Recommendation Report for Planning Permission for Works or Extension to a Dwelling

REF NO: FP/59/22/HH

LOCATION: Beach House
Havelock Close
Felpham
PO22 7AY

PROPOSAL: Erection of single storey side and rear extension, installation of front lower level wall and external alterations including rendering and cladding following the demolition of existing front wall, side porch and rear conservatory.

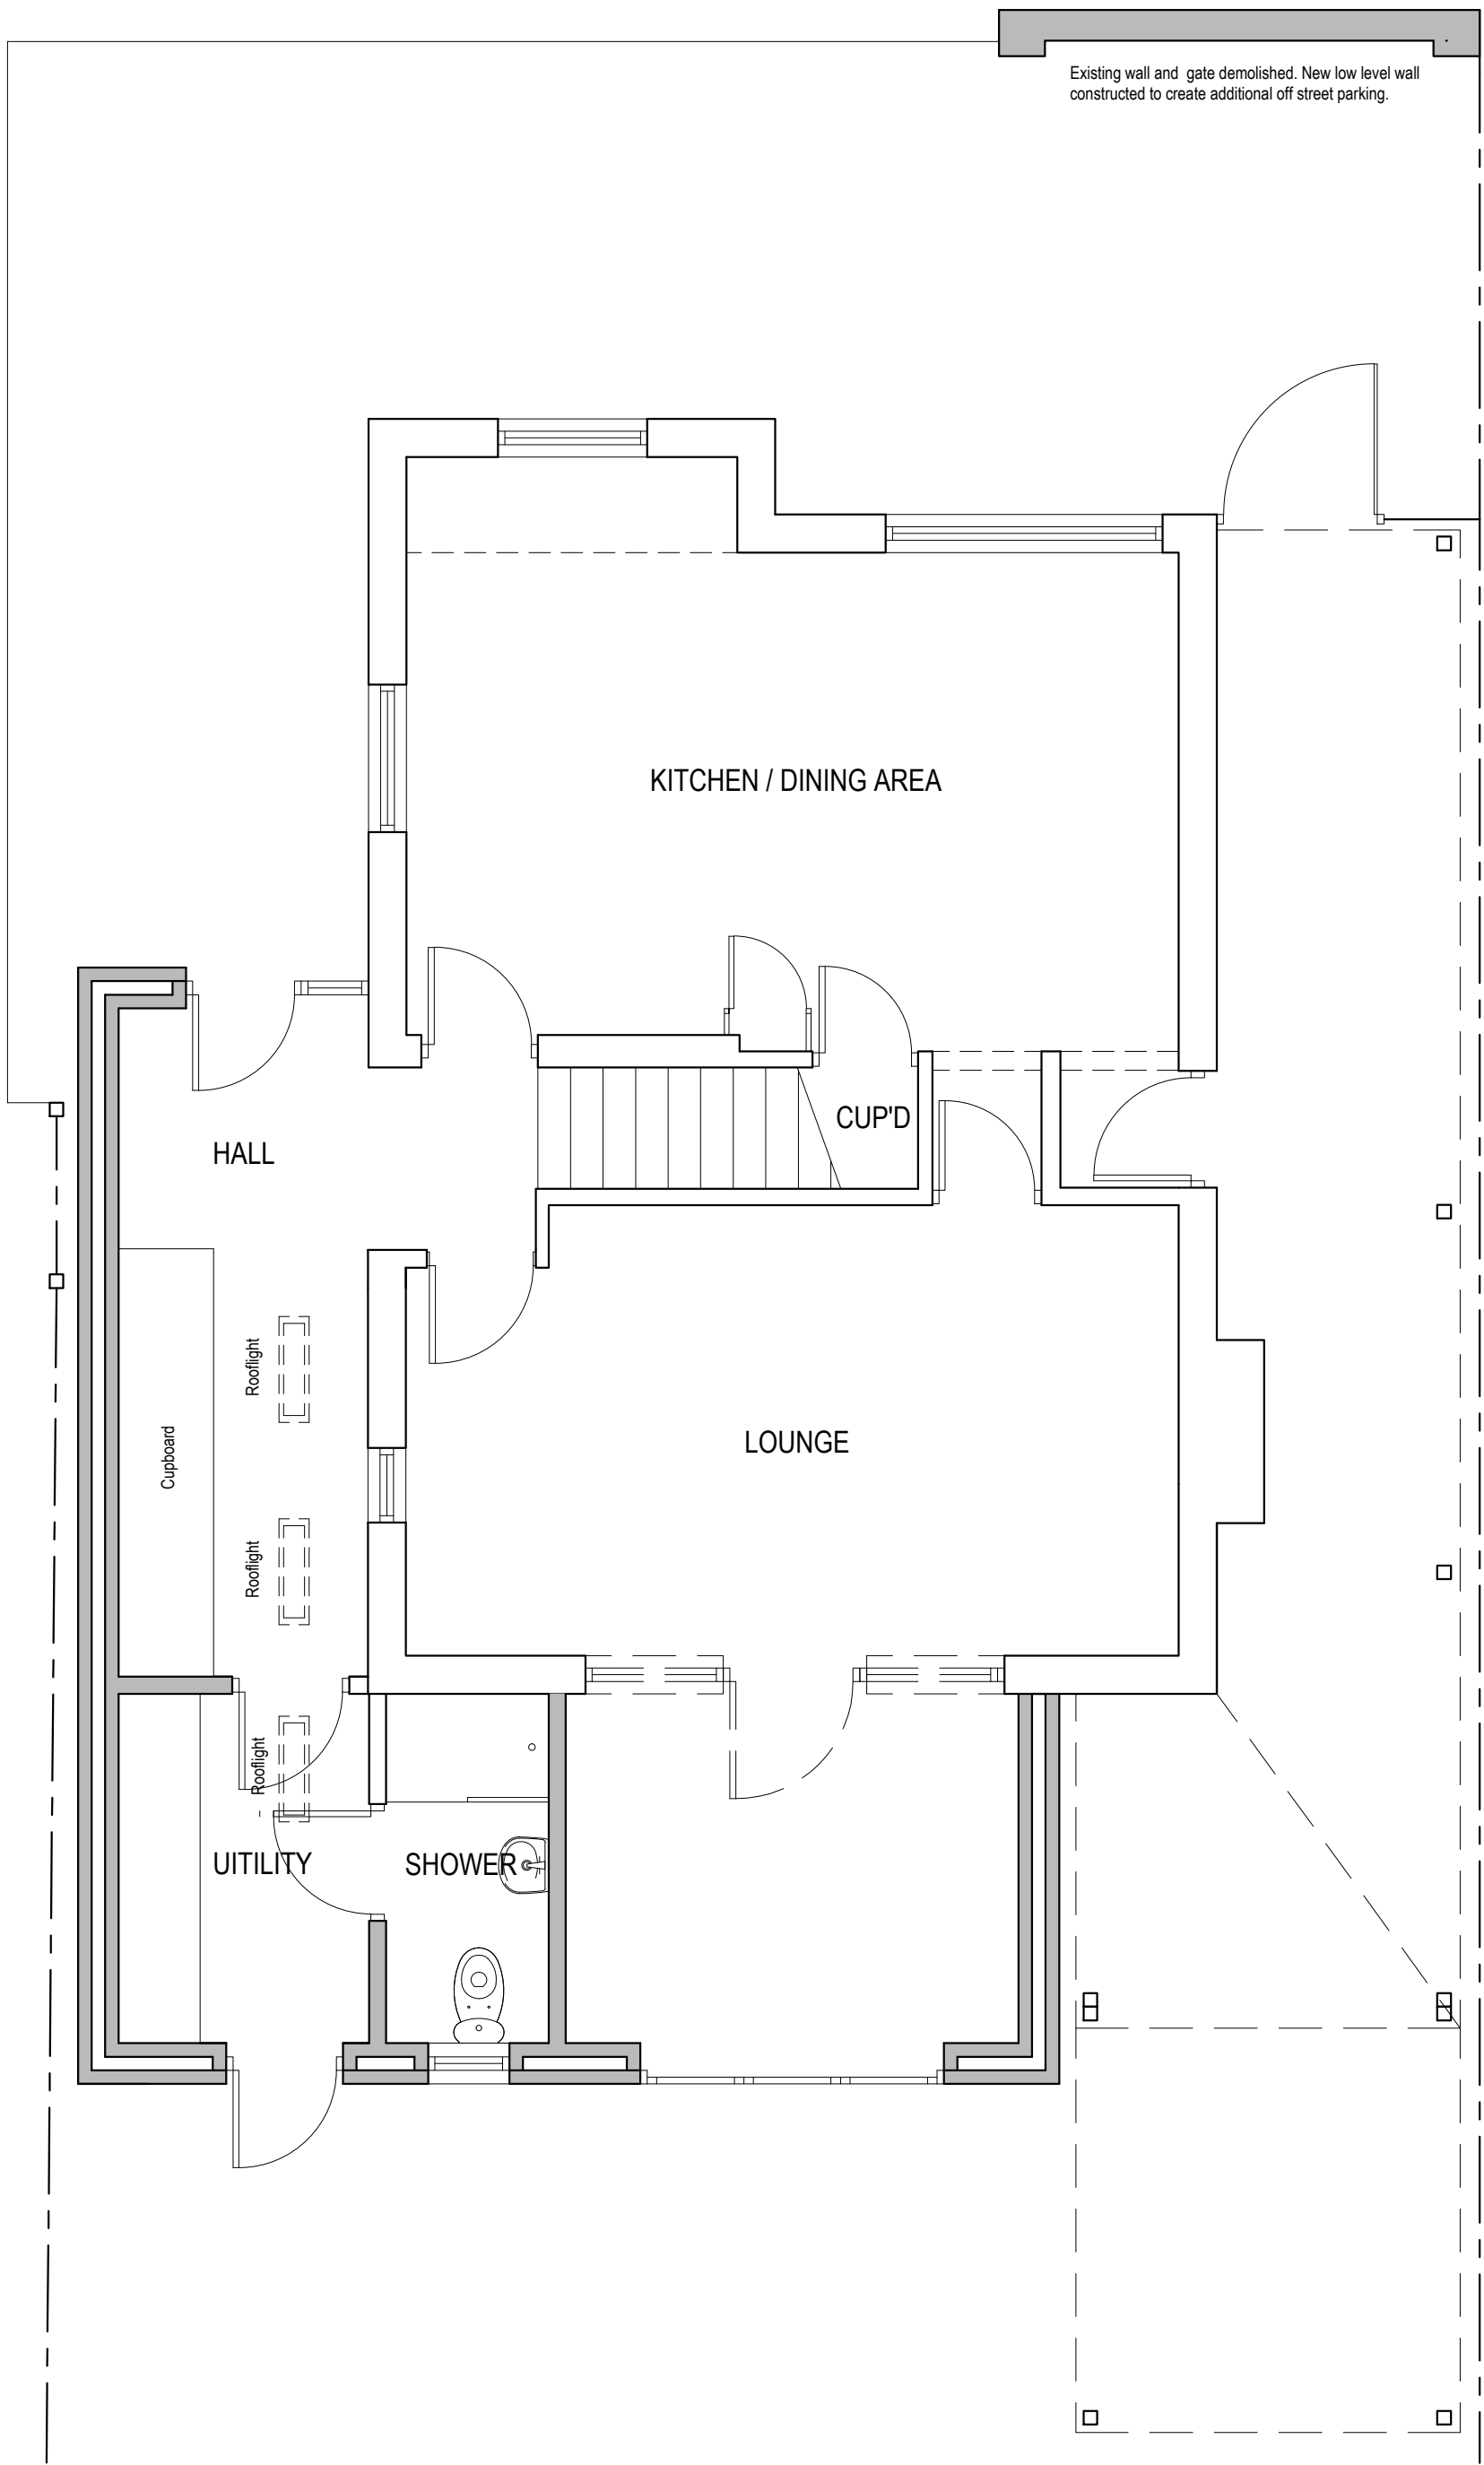
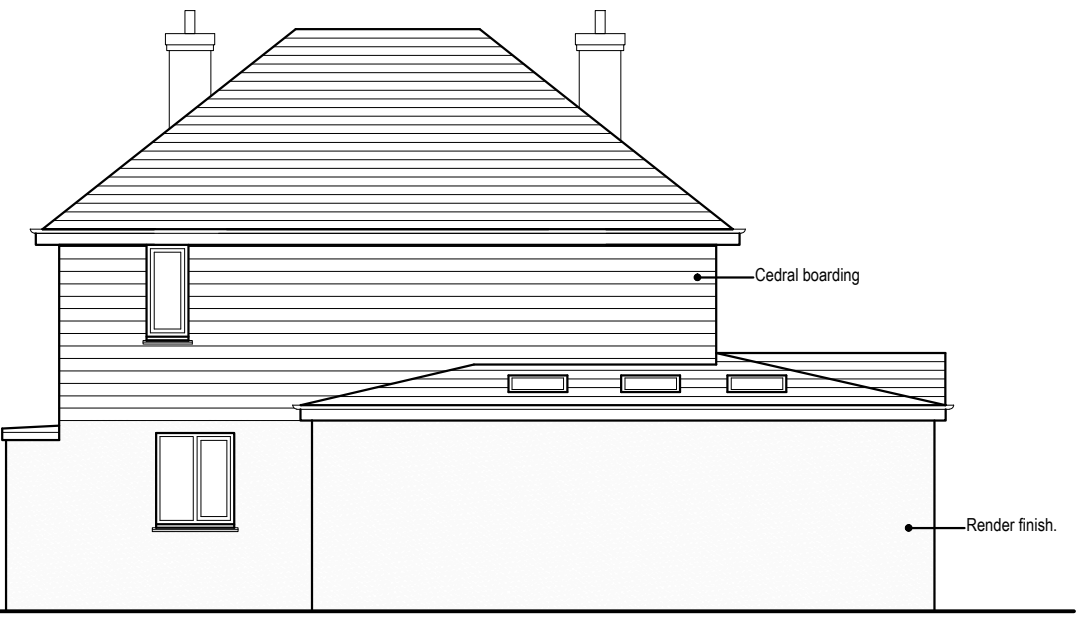
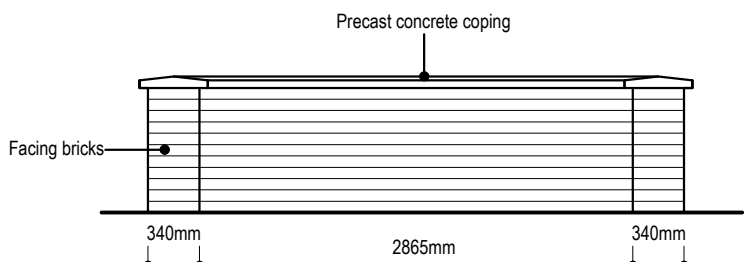
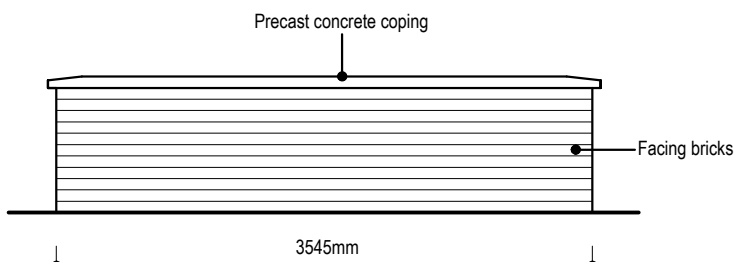
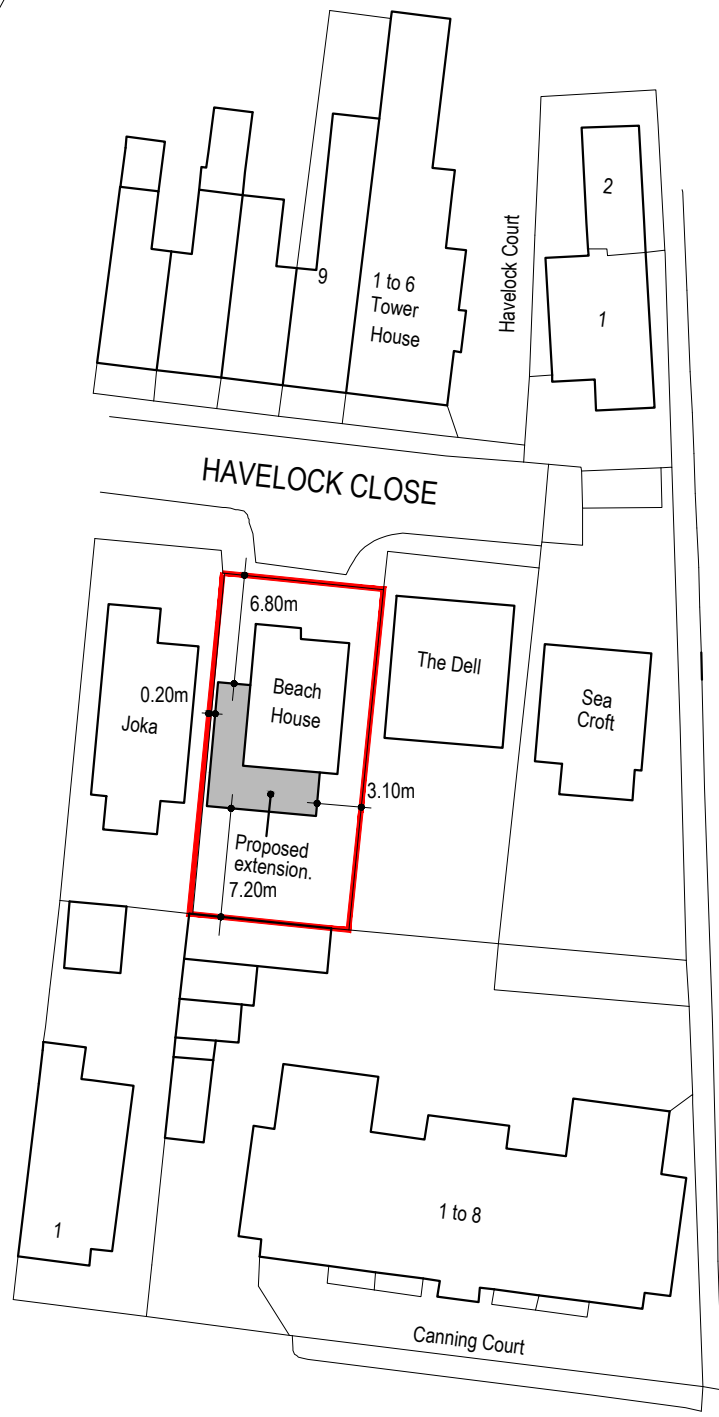
The proposed rear to side wrap around extension projects approx. 2.9m off of the rear elevation and 2.1m off the side (West) elevation. This extension is to extend approx. 7.2m across the rear elevation and 8.2m across the side elevation. It is to reach a peak height of approx. 3.4m featuring a shallow hipped roof design with eaves at approx. 2.6m. The scale of this extension relative to the host dwelling is large however, it makes efficient use of the existing footprint and is of a similar scale to the existing extensions. This extension is to feature a rendered finish and concrete roof tiles which are acceptable.

The proposed new low level front wall will replace an existing front low level wall. It is to be constructed of face brickwork with concrete coping and reach a height of approx. 0.9m which is of a similar scale to that which already exists. There is a small section of the existing wall running from the front elevation of the house to the front site boundary that would not be replaced. This would allow for an additional off-street parking space, resulting in 2 overall. This is an appropriate change, bringing the property in line with the Arun Parking Standards supplementary planning document.

The external alterations are to include cladding of the first-floor external elevations and rendering of the ground floor external elevations. The locality is characterised by a variety of materials and colorations including render and cladding. The materials are not out of character within the locality and feature colorations which are white render and light grey cladding. These are acceptable as they are coherent with what can be seen along the street. They are, therefore, representative of the local vernacular and compliant with Section L of the Arun Design Guide.

The scale and siting of the proposed works are such that there would be no intersection of any 45-degree light accessibility line or 60-degree rear sight lines. As such, there will be no adverse impacts by way of overbearing or overshadowing on any neighbouring properties.

There is to be 3 No. new ground floor viewpoints. These are not significantly different to those which already exist and look out to the rear of the property. These will give rise to no adverse impacts by way of overlooking on any neighbouring properties.
